City of Albuquerque Stormwater Construction Site Inspection Report

ESC File No.	B11E010A	Project Name:	Viva Paradise Town Homes		
NPDES Id. No.	NMR1002ZX	Location:	5512 Buglo Ave. NW		
11/4/2021	Owner	Contractor			
Operator	Buglo Properties, LLC.				
Contact name & title	John Lowe	Ryan Mayfield			
e-mail	jlowe14@comcast.net	mrtrim777@yahoo.com			
Contact Phone #	505-688-6834	505-321-2082			
COA Inspector	Doug Hughes	Start/End Time:	9:45 AM-10:20 AM		
Construction Phase:	Interior finish and landscaping				
Type of Inspection:		Storm Event	Past Storm Event >0.25"	311/Complaint	Regular
Weather at time of inspection?		clear		Temperature: ~	45
Estimated date of last storm 0.25" or greater		10/1/2021

TEMPORARY EROSION AND SEDIMENT CONTROL PLAN

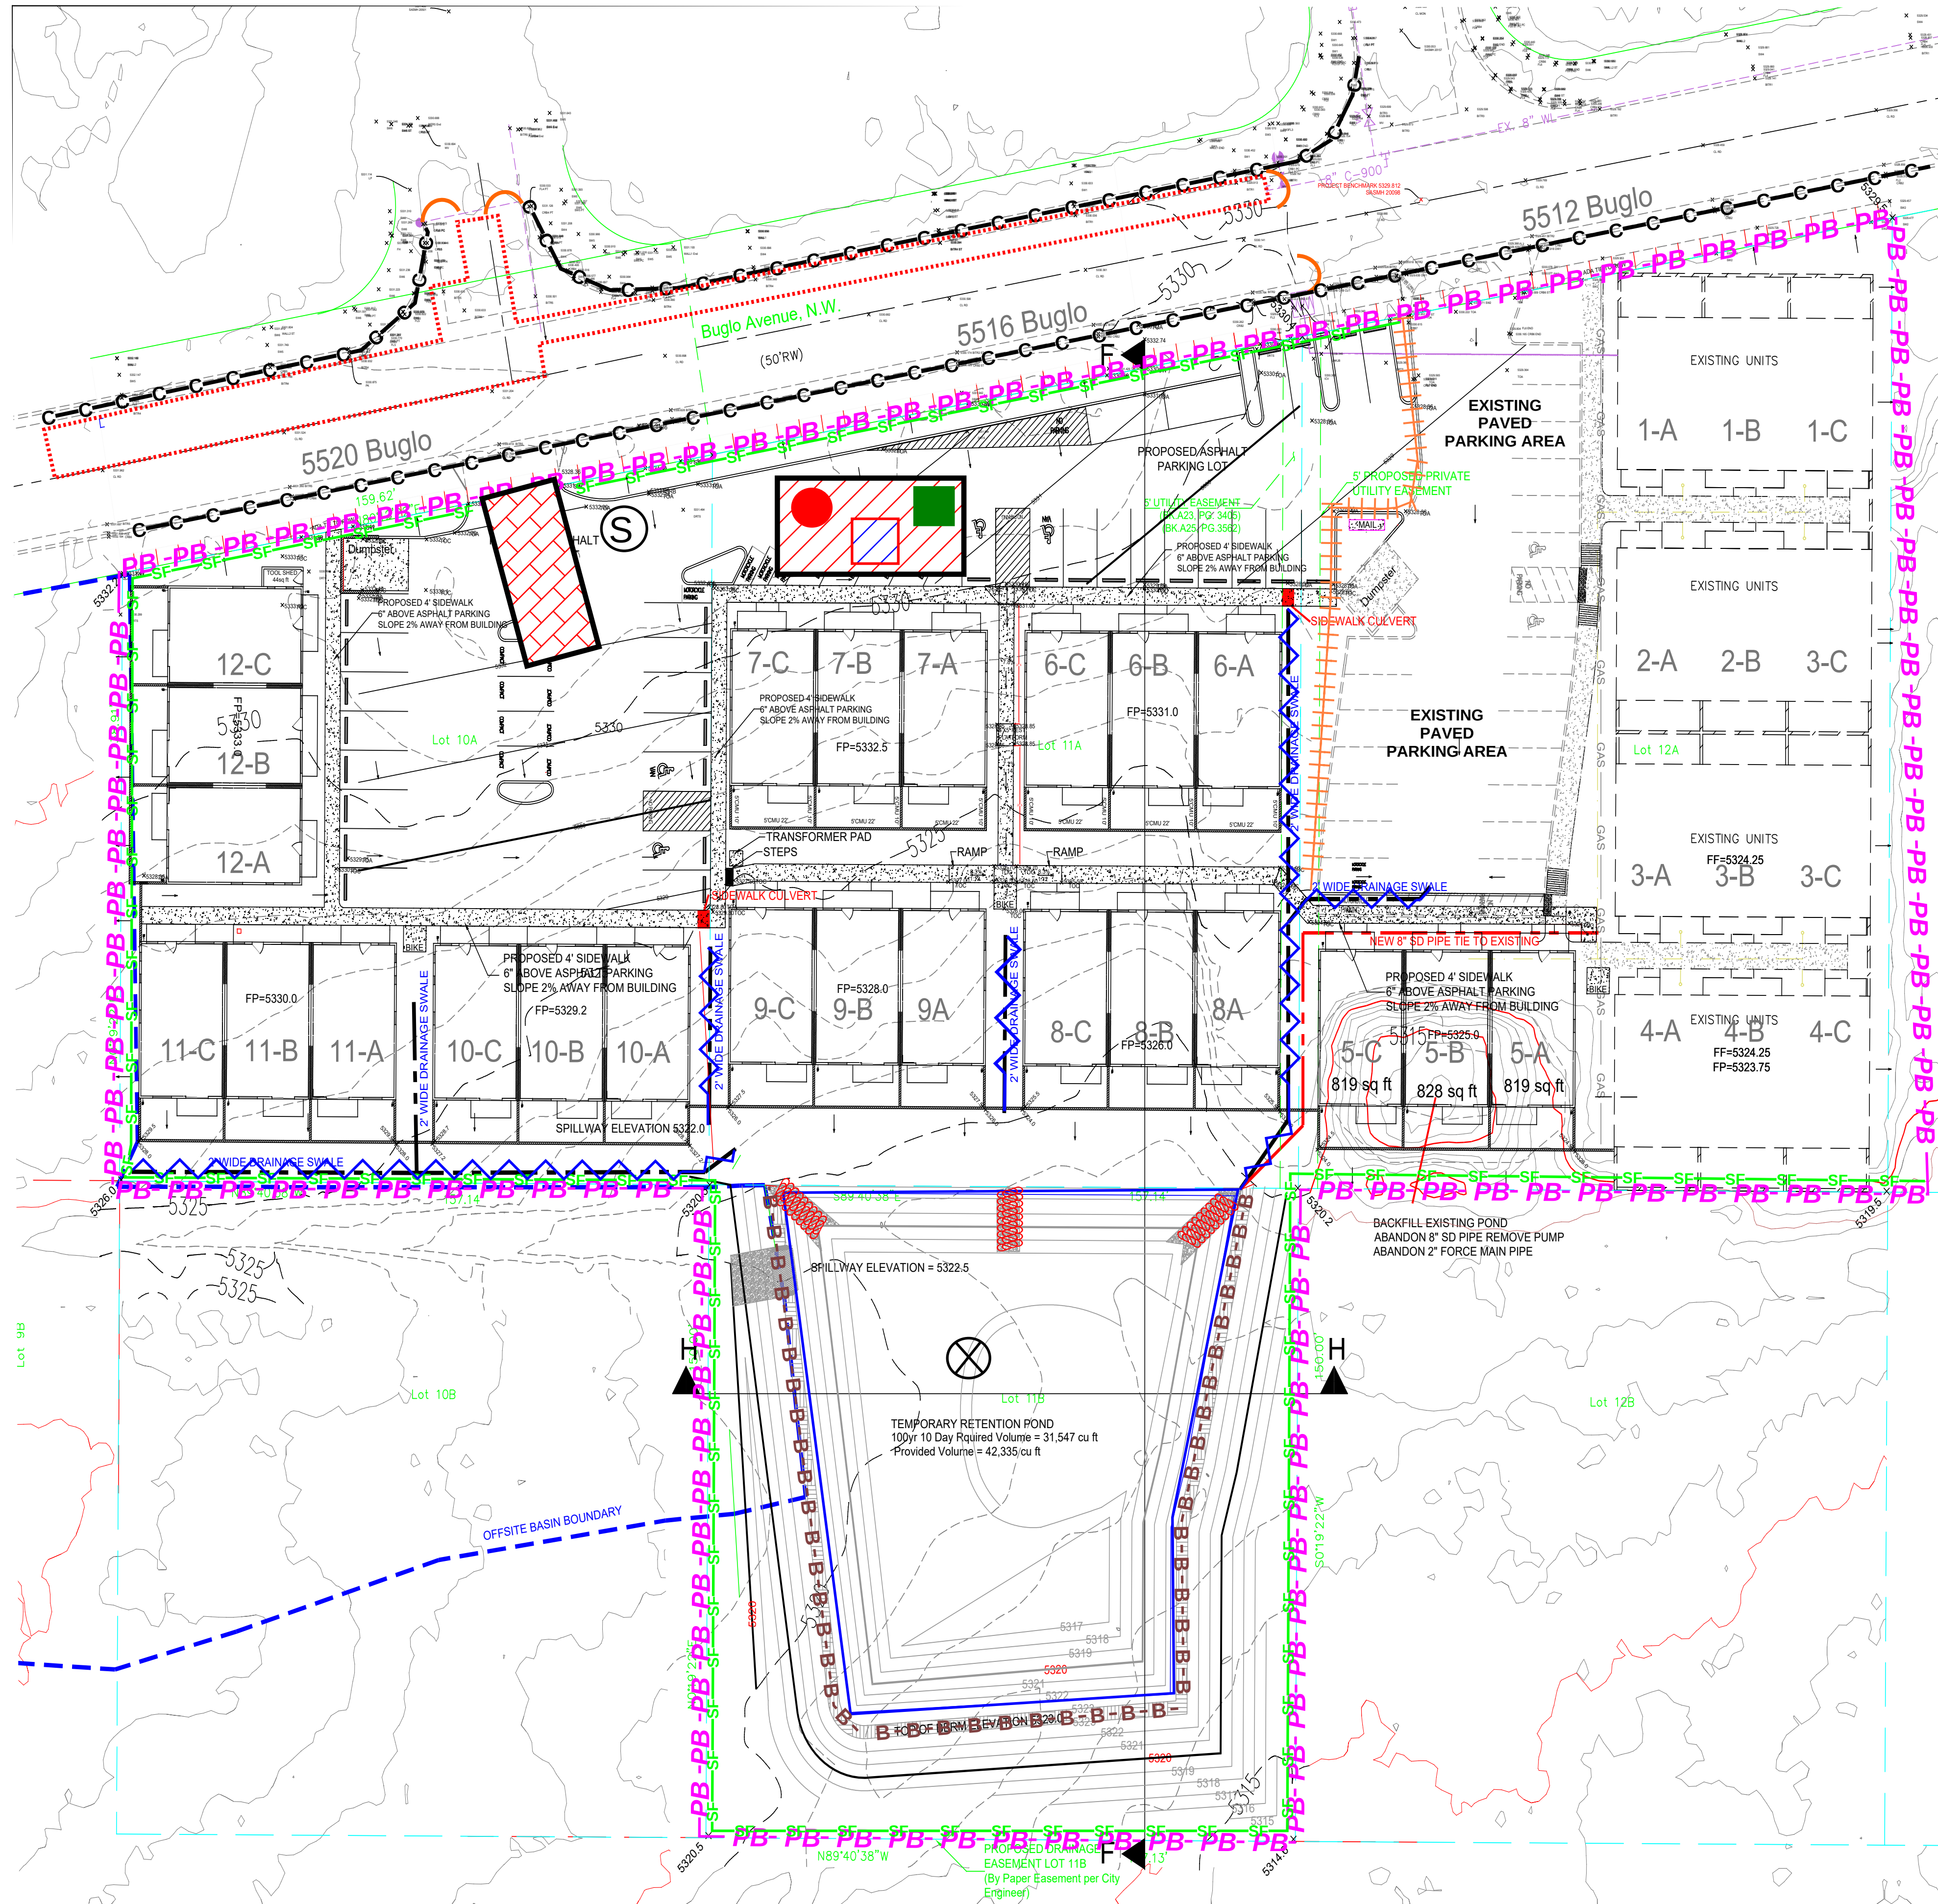
Item Number	Deficiency/ Corrective Action				
1	SWPPP not up to date. Need to obtain signatures for SWPPP certification & inspection reports.				
2					
3					
4					
5					
2.1	Discharge off site? (Y/N)	no			
4	Self Inspection Reports	Requested	Latest report Date:	6/4/2021

Notes:	Site is ready for landscaping. Recommend city spec 1012 Native Seed and Agregate Mulch or better on all disturbed areas both onsite and on the adjacent property where land disturbing activities associated with this project have destroid the vegetation.
	Access roads (12' wide)don't have to be stabilized.
